ENG-SF21021-R4-CDs.pdf Markup Summary

Subject: Text Box
Page Index: 21
Date: 4/21/2022 1:03:31 PM
Author: CDurham
Color: ■
Layer:
Space:
Page Label: [1] CHANNEL PROFILE 1

RETREAT AT TIMBERRIDGE FILING NO. 2
CONSTRUCTION PLANS
HEC-RAS ANALYSIS
CHANNEL CL PROFILE (STA: 1+00 - 14+00)

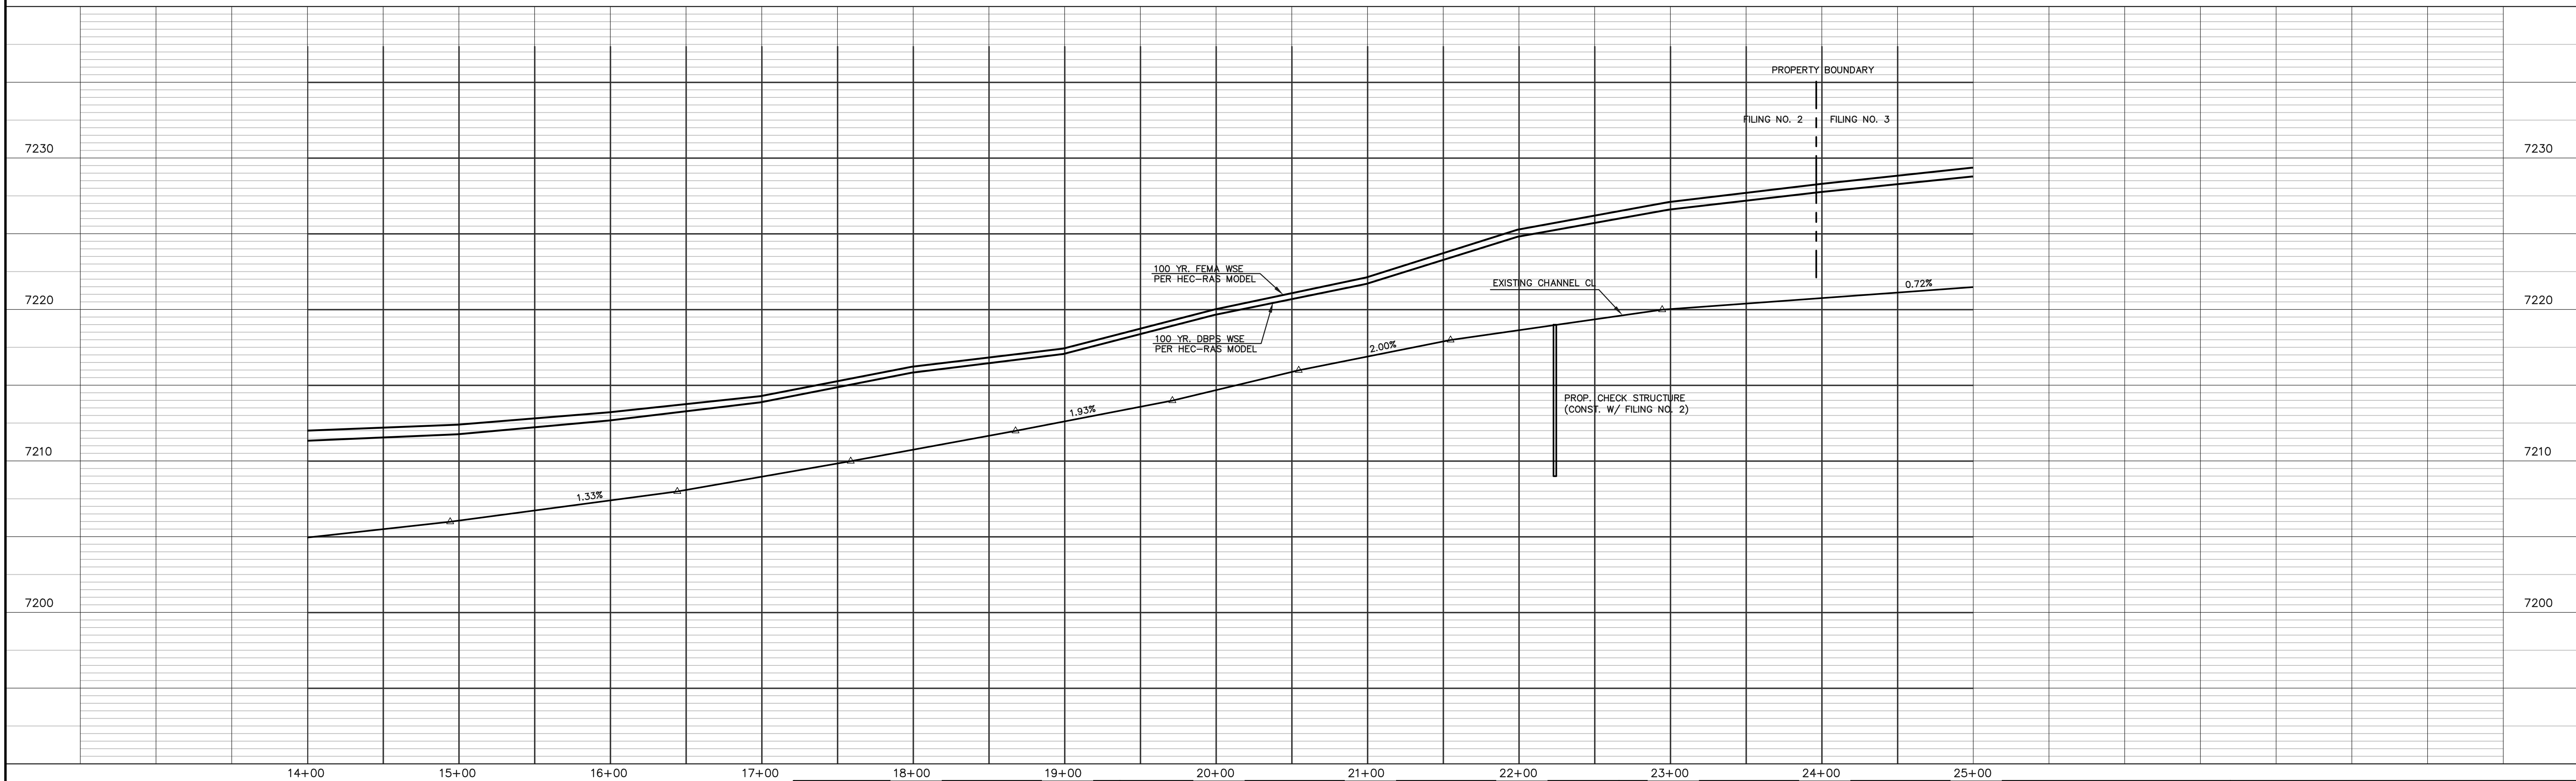
Label maintenance access points on east side of channel

Note: these future lots will need to be revised based on calculated floodplain unless FEMA hydrology is changed
